Our ref: PL00490033

Your ref: EN010092

**PLANNING ACT 2008 : THURROCK POWER, PROPOSED THURROCK FLEXIBLE
GENERATION PLANT**

Historic England Deadline 4 Response

Figure 3.2 Historic Landscape Character of the site and surrounding area

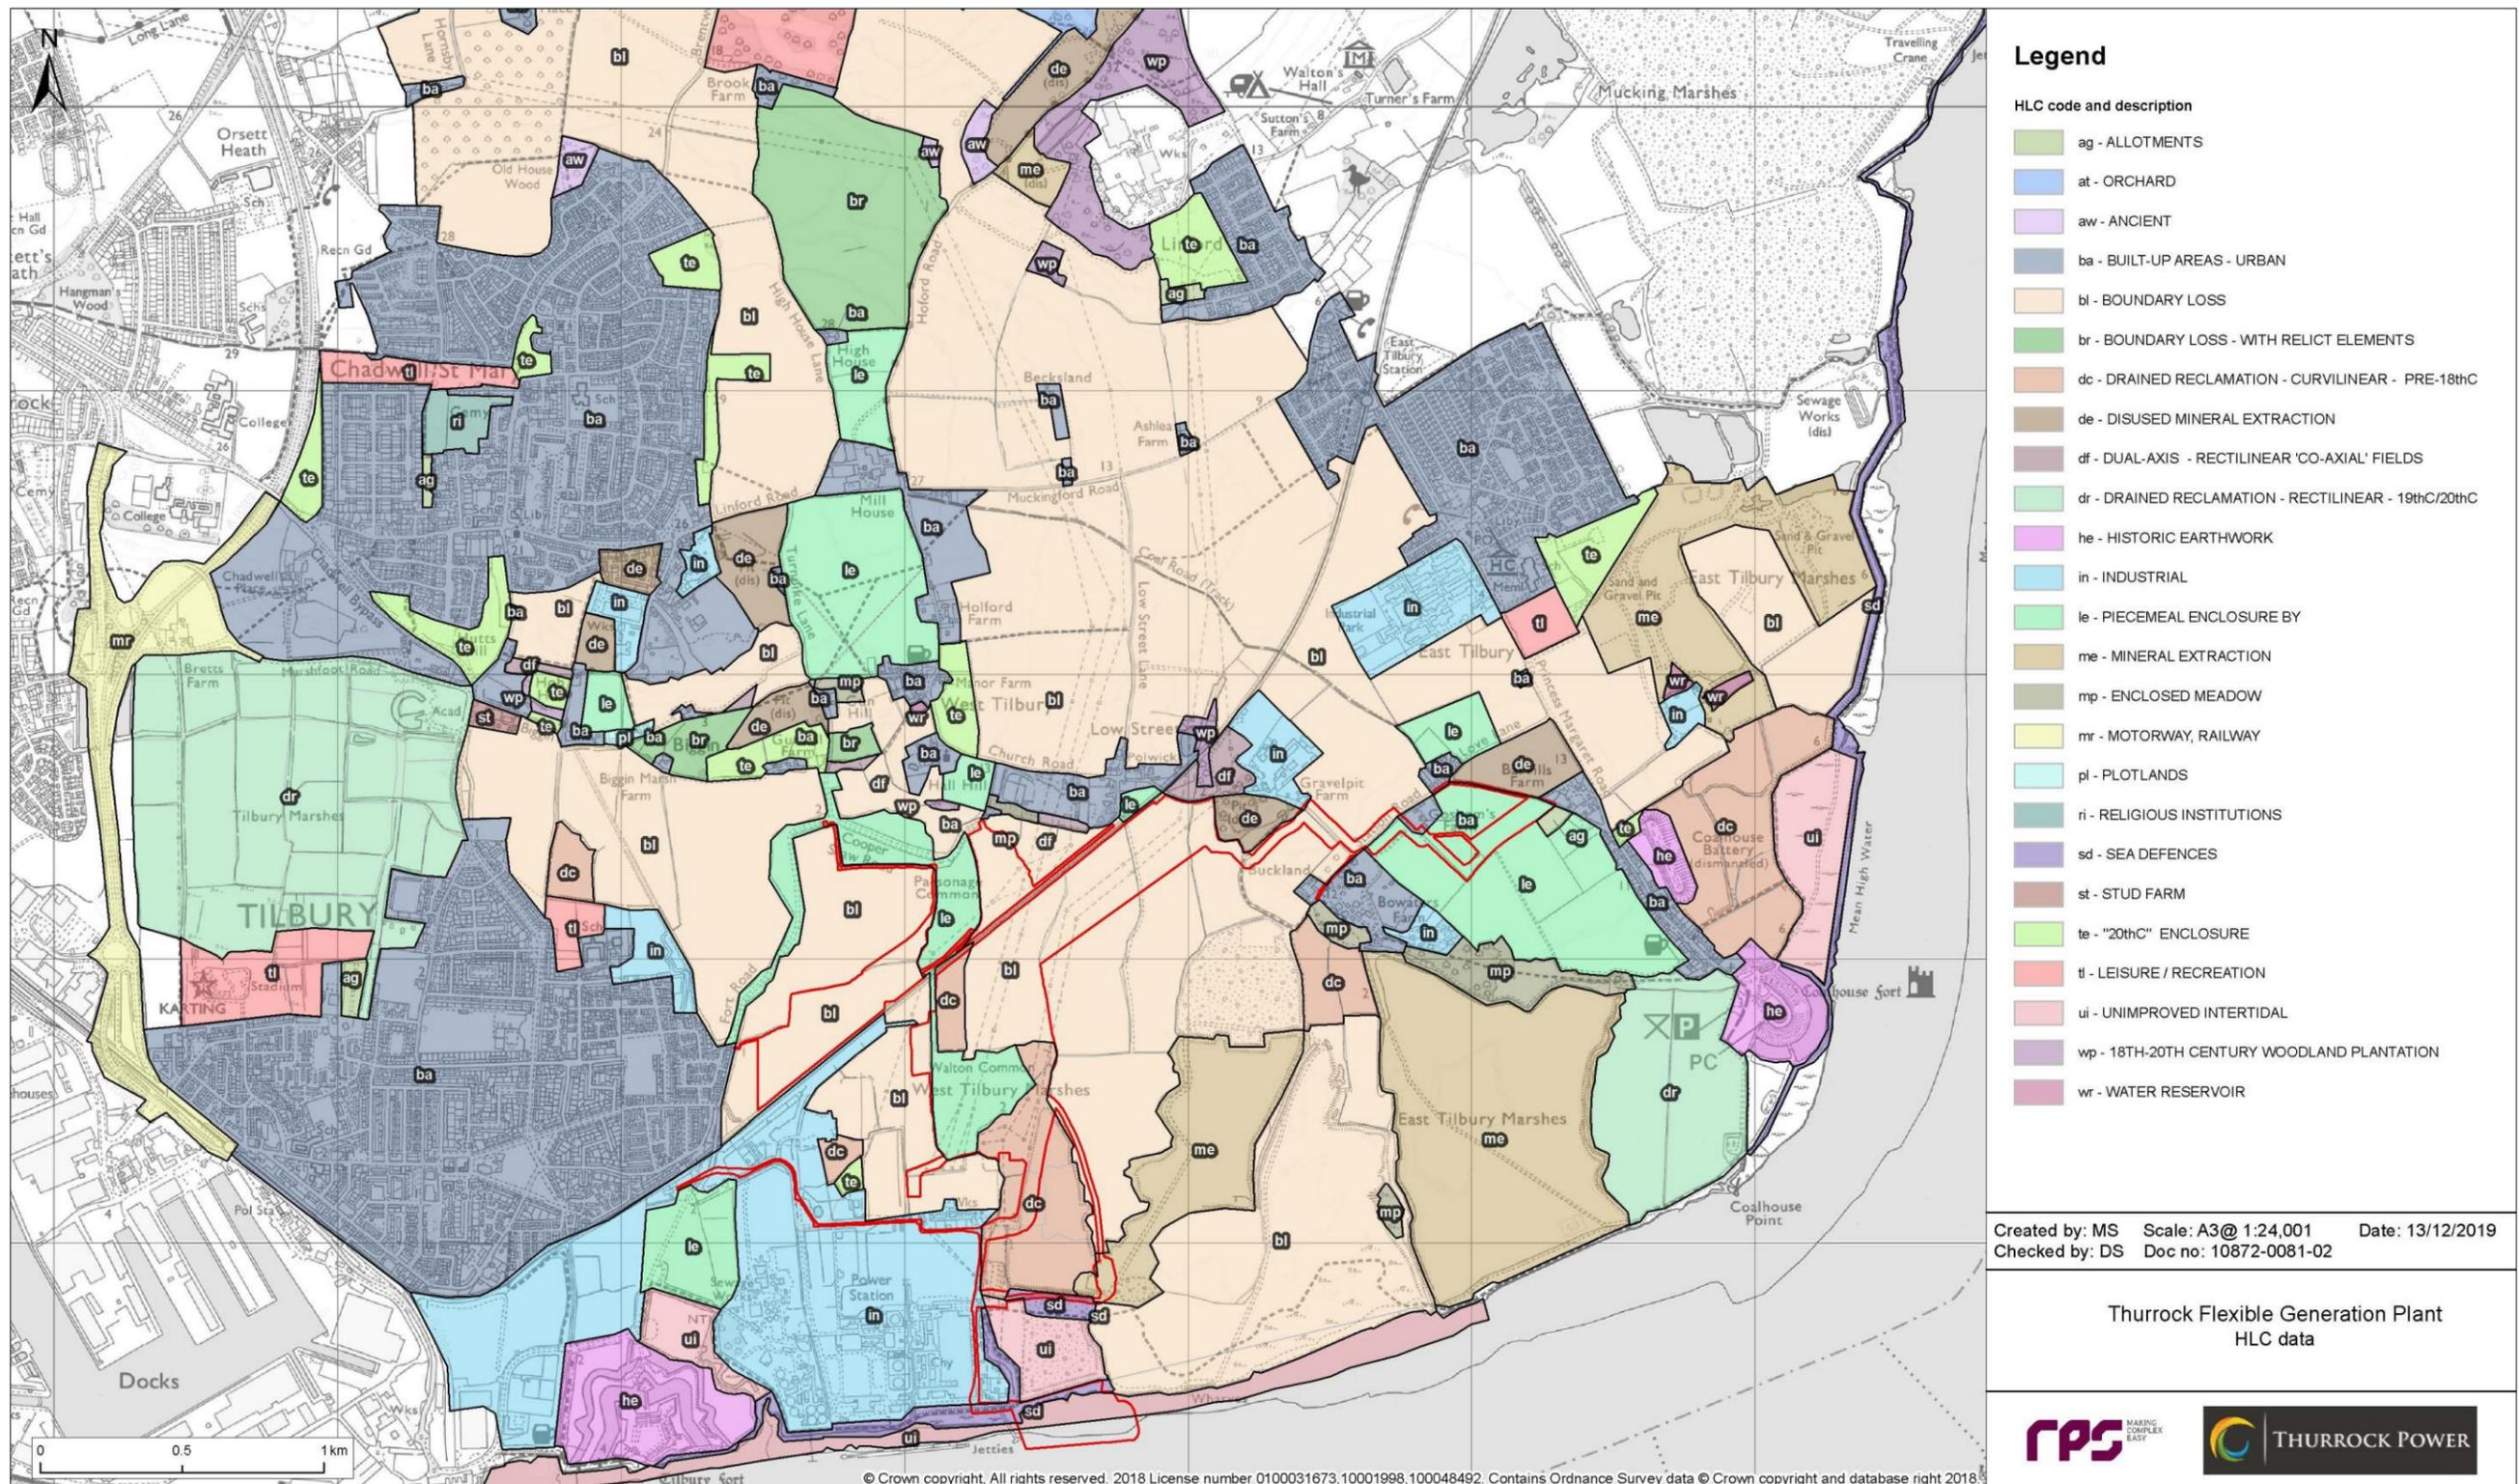
We also believe the proposed development will result in a serious level of harm to the historic landscape – specifically, the complete loss of an early historic common - one of five contiguous commons that survive remarkably intact in the West Tilbury Marshes.

Walton Common, also known historically as 'Worden', 'Waddam' and 'Wotton' Common, is an historic estuarine marsh common which survives as a complete landscape entity within the former West Tilbury Marshes. The irregular ditched boundaries reflect ancient creek patterns.

Walton Common is one of five historically interlinked historic commons on West Tilbury Marshes, along with Tilbury Fort Common, Fort Road Common, Hallhill Common and Parsonage Common. Exceptionally, all five commons survive almost intact within the modern landscape, and this elevates their significance in terms of their group value. The earliest recorded survey is 1584 and, in a detailed landscape history of West Tilbury parish,¹ it has been stated that they may be much earlier and pre-conquest in origin. Bingley (2006, 205) suggests Walton Common is possibly associated 'with Saxon grazing or fishing zones upon the yet-unreclaimed alluvial marsh.'

There is also a surviving trackway or driveway on the north side of Walton Common, defined by two parallel linear N to S aligned ditches, that connects Walton Common with Parsonage Common (although this has been bisected by the construction in the late 19th century railway). The trackway, known historically as 'Walton' or 'Waddam Wall', is one of a number of green 'walls', sometimes called 'manorways' or 'causeys', which ranged outwards from West Tilbury's hills. Bingley (2006, 138) states that 'Walton Wall' was probably pre-conquest in origin, connecting West Tilbury Hall next to St James' Church and its sheepwalks.

We believe the removal of Walton Common is a significant effect and the magnitude of impact is major adverse. This is because the specific parcel of land that is Walton Common will be almost entirely removed as a meaningful landscape entity by the proposed powerstation.
